WEST SUSSEX COUNTY COUNCIL CONSULTATION

TO:	Arun District Council FAO: Michael Eastman
FROM:	WSCC - Highways Authority
DATE:	23 February 2021
LOCATION:	Land north of Felpham
SUBJECT:	FP/248/20/PL Revised details relevant to the sport pitch & changing facilities building (previously approved under Y/38/09/). This site also lies within the parish of Yapton & is in CIL Zone 4 (Zero Rated) as other development.
DATE OF SITE VISIT:	n/a
RECOMMENDATION:	Advice
S106 CONTRIBUTION TOTAL:	n/a

Title: Engineering Layout

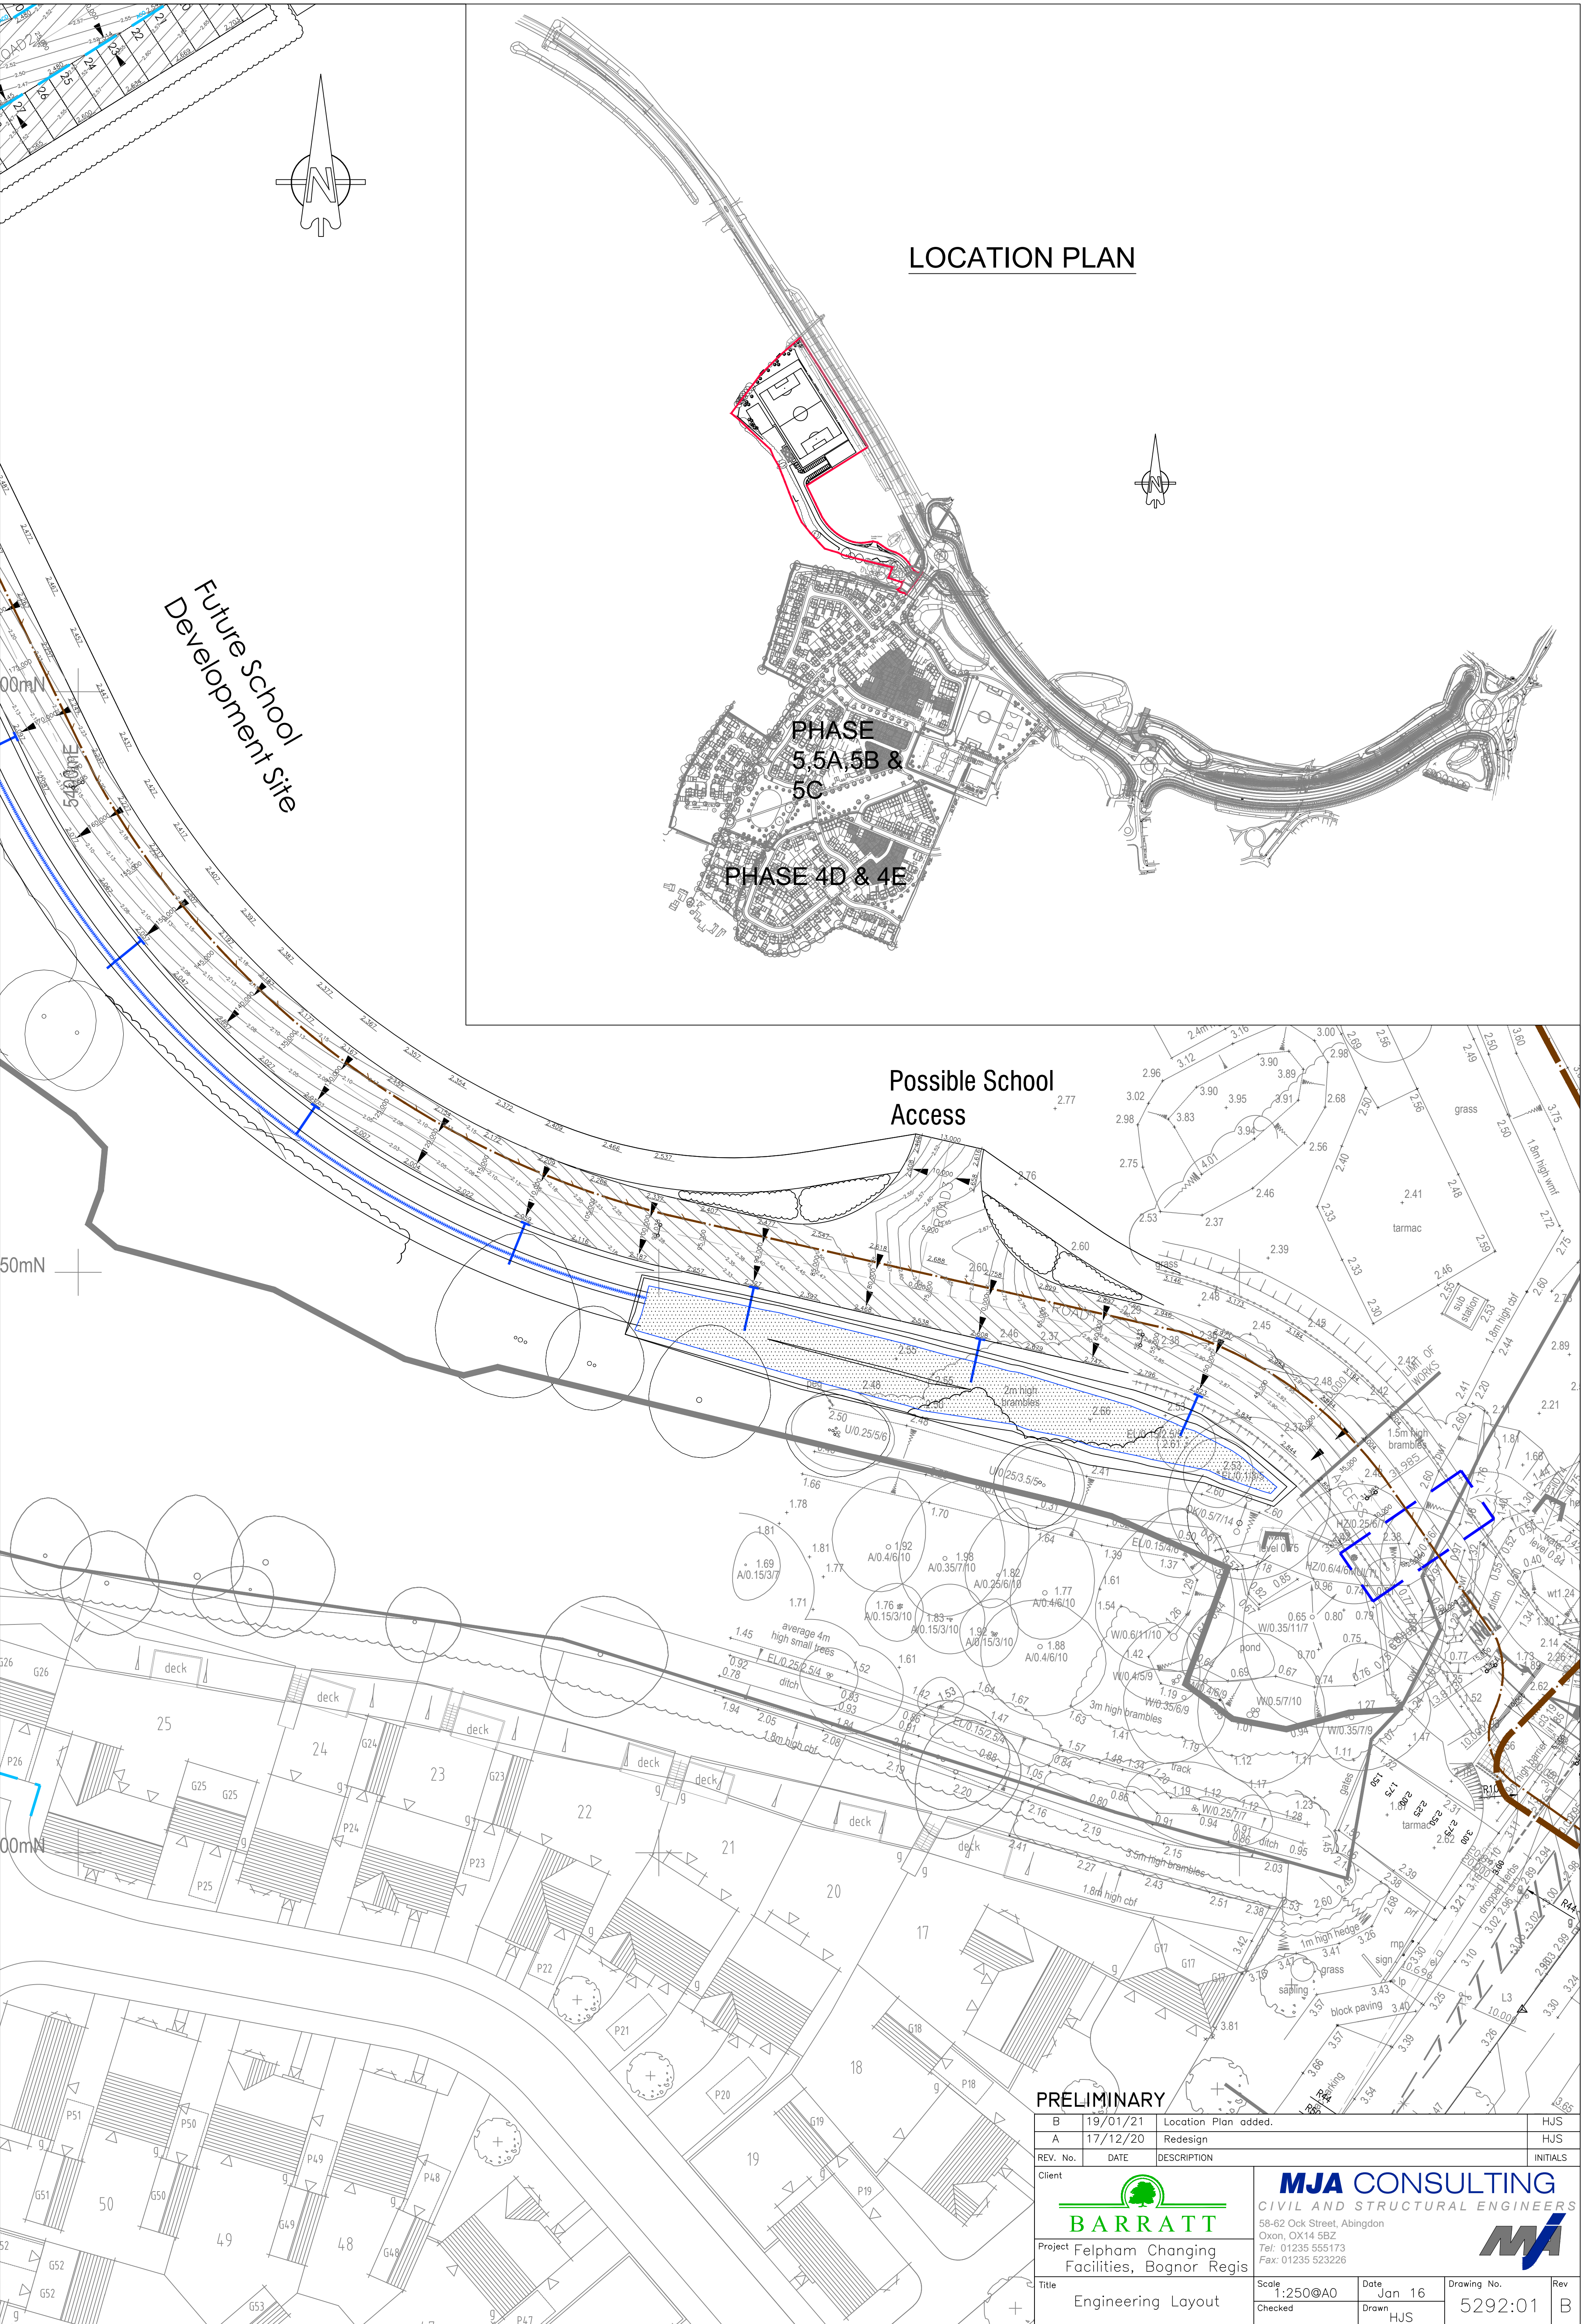
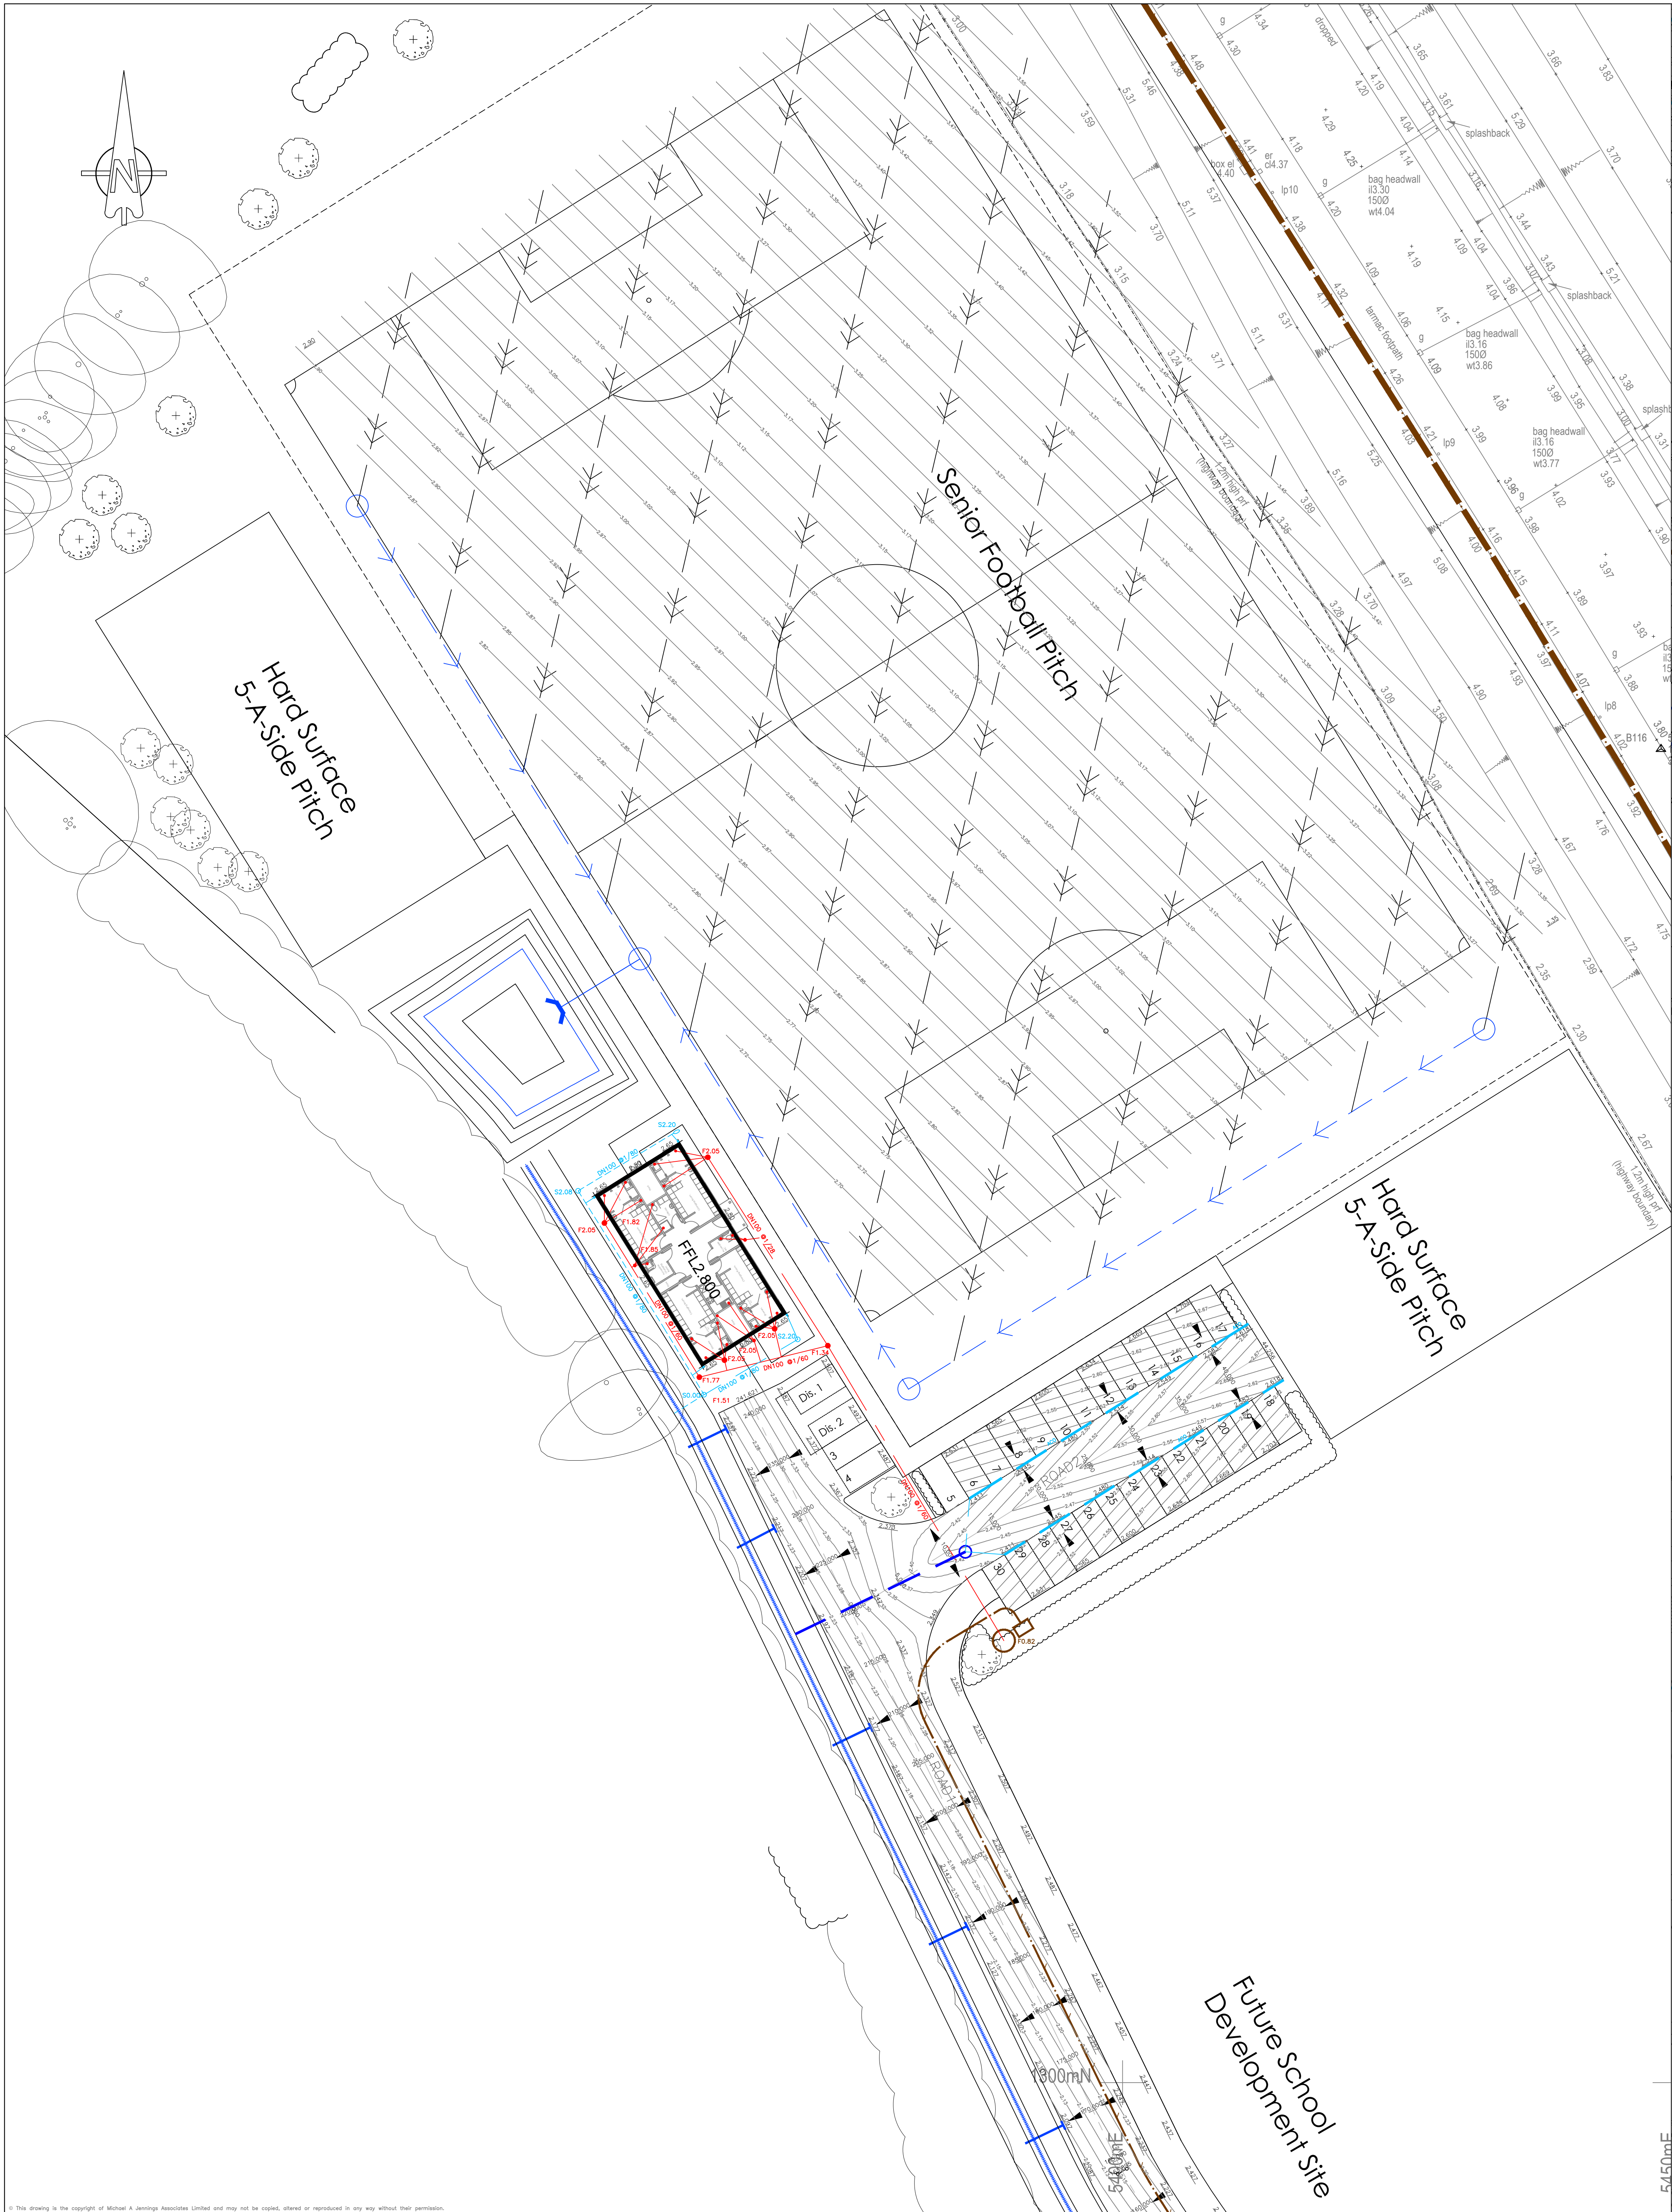
- Parking in line with the latest WSCC parameters
- More clarity on the access road/footway and its dimensions
